Helios Renewable Energy Project

The Applicant's Responses to Deadline 8 Submissions

Planning Inspectorate Reference: EN010140

May 2025

## **Environmental Statement Figure 3.16: Landscape Strategy Plan**

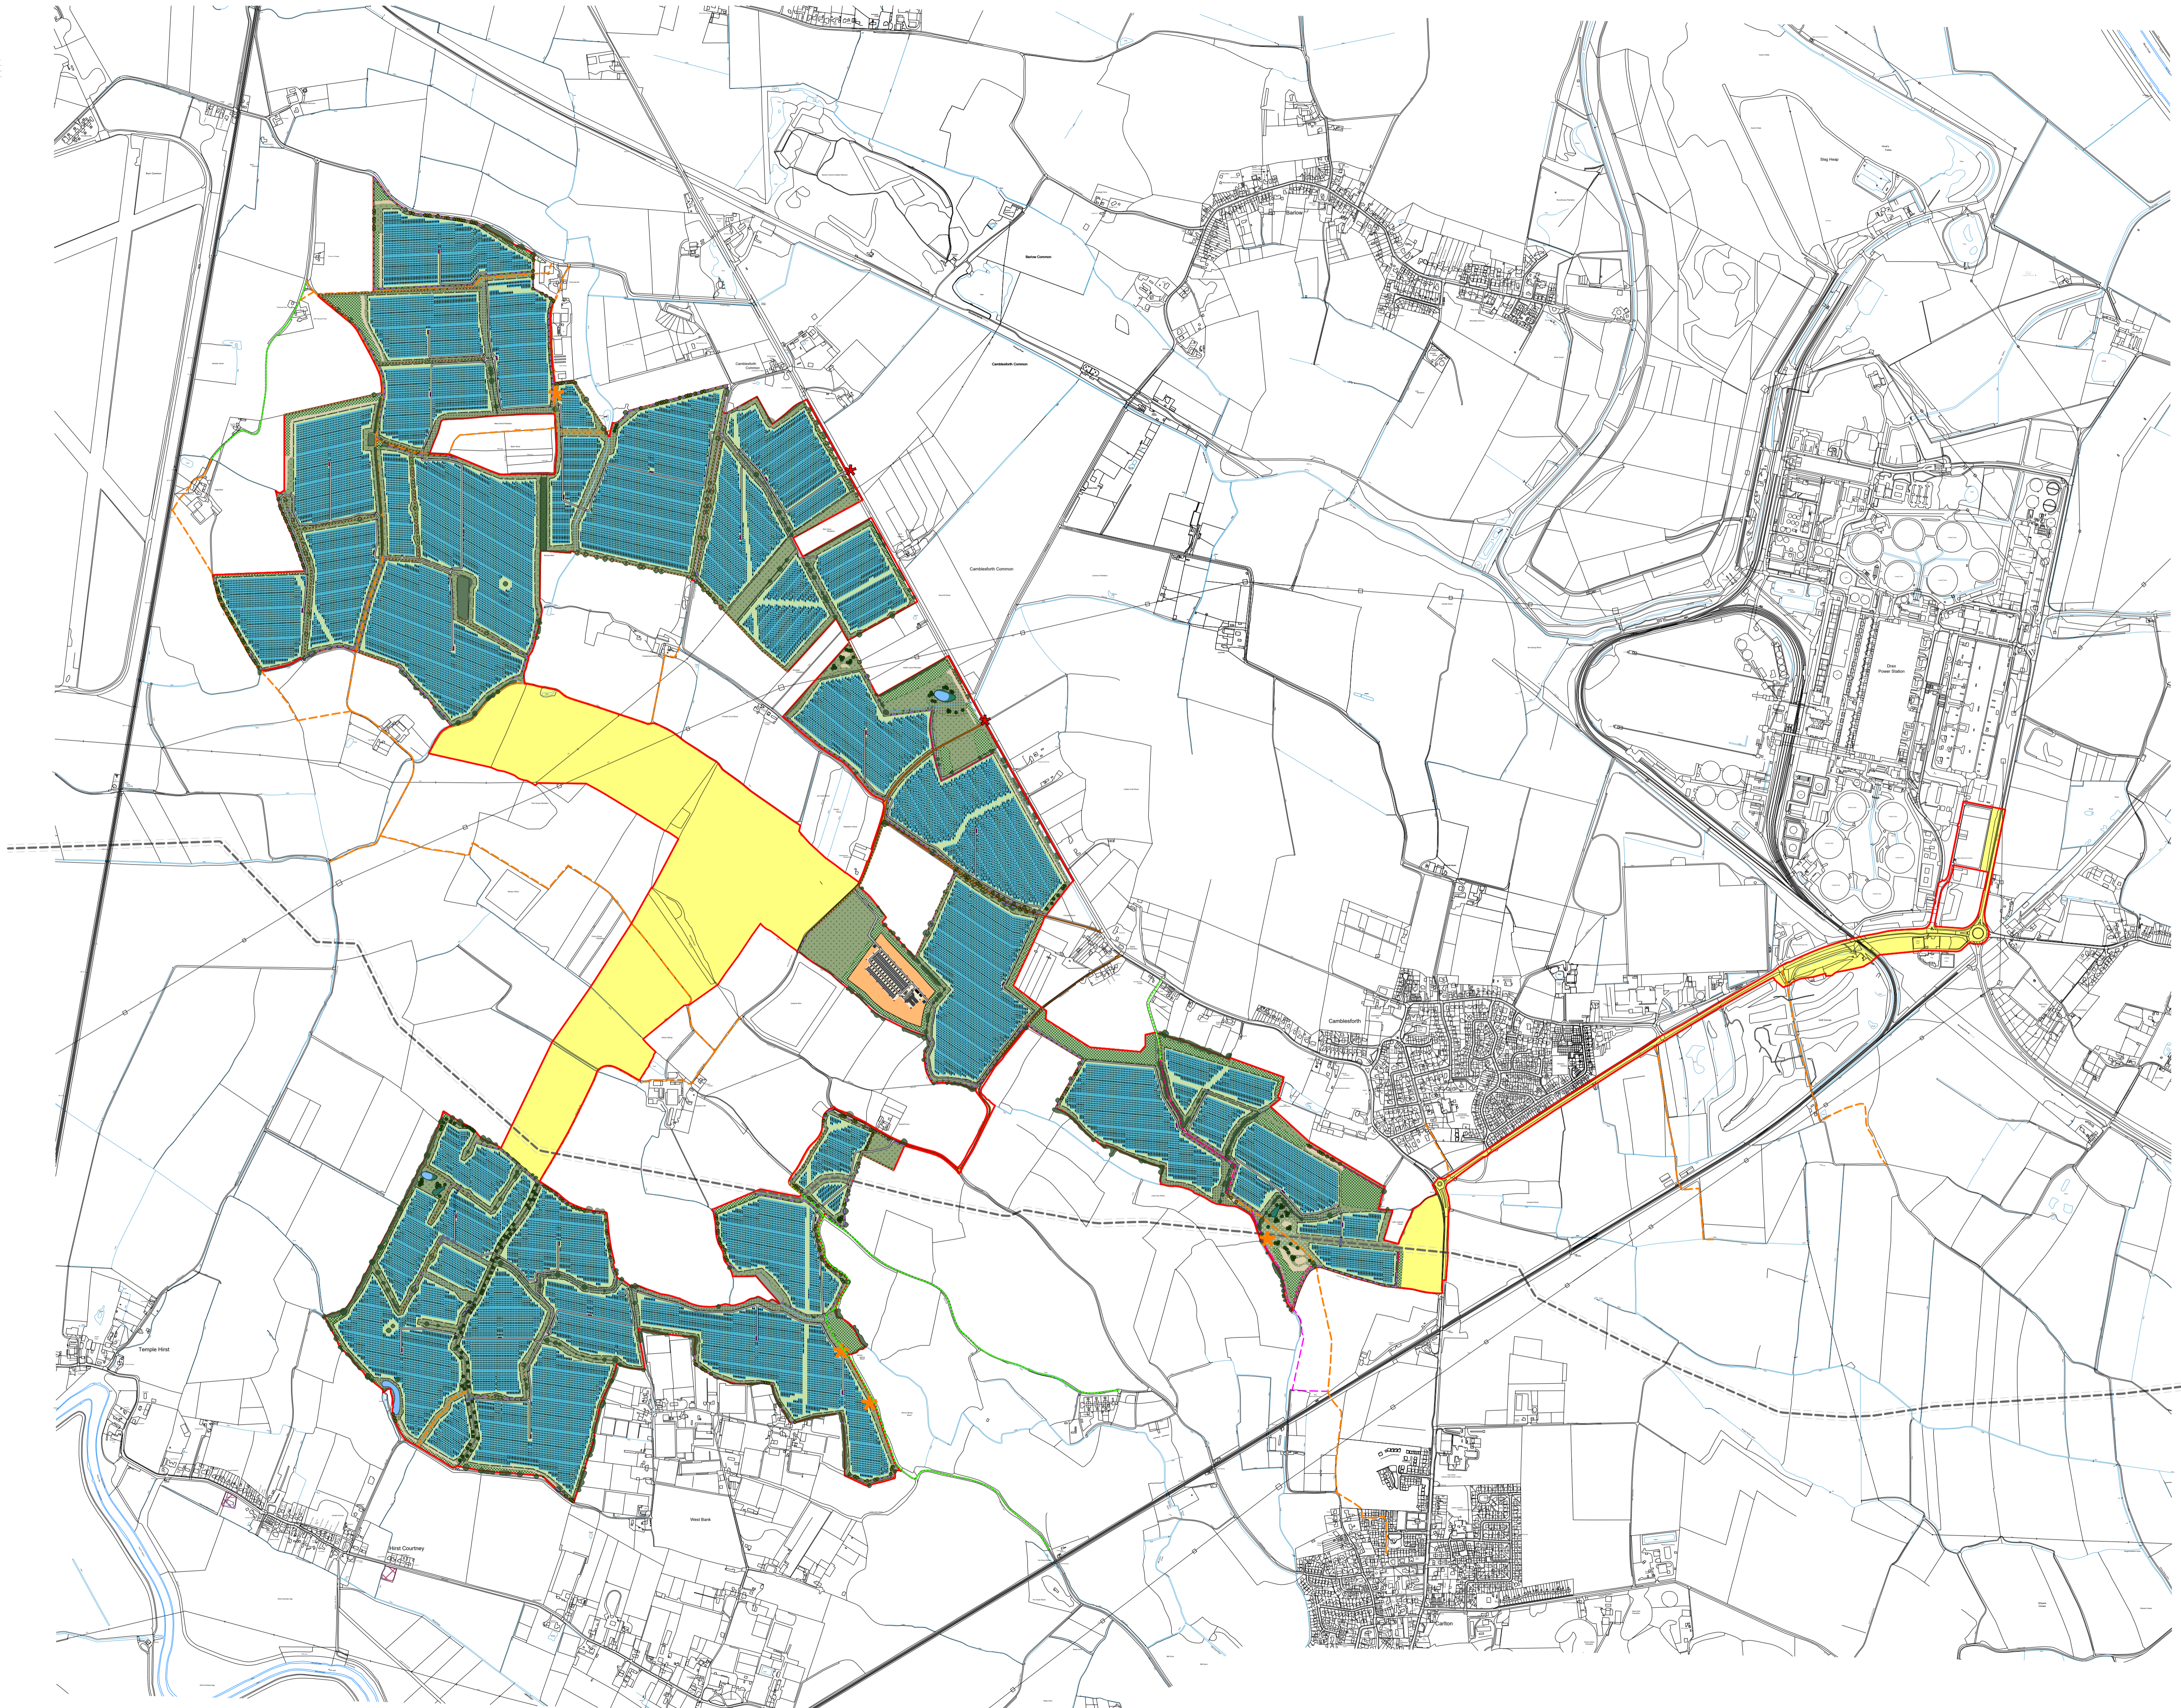
3.1.4. In its Deadline 8 response, Natural England stated that it welcomes that that 10% biodiversity net gain in habitat units is secured within the dDCO however it advised that the previous requirement to include 'details of habitat creation' could encompass all habitat creation including mitigation proposals for SPA birds, and advised that any changes to the wording would need to ensure this is addressed suitably.

3.1.5. The Applicant considers that this is not of concern as Requirement 10 (2) (c) and (d) require that management of the proposed landscaping throughout the lifetime of the authorised development and landscaping details will need to be specified in the LEMP for approval by the local planning authority in consultation with Natural England. Furthermore, Work No. 4 and 9 (as set out in Schedule 1 Authorised Development of the dDCO and Outline Design Principles Document Rev. 1 [REP7-021]) require that planting and ecological works will be undertaken in accordance

with the oLEMP **[REP4-019]** and ES Figure 3.16 Landscape Strategy Plan **[APP-054]** which identify that the Proposed Development will meet biodiversity net gain objectives beyond 10% and with ecological and landscaping works greater than the creation of ground nesting bird habitats. It is therefore demonstrated that the concern raised by Natural England is already inherently dealt with in the dDCO and associated documents that no amendments need to be made to Requirement 10 (2(b)) of the dDCO.
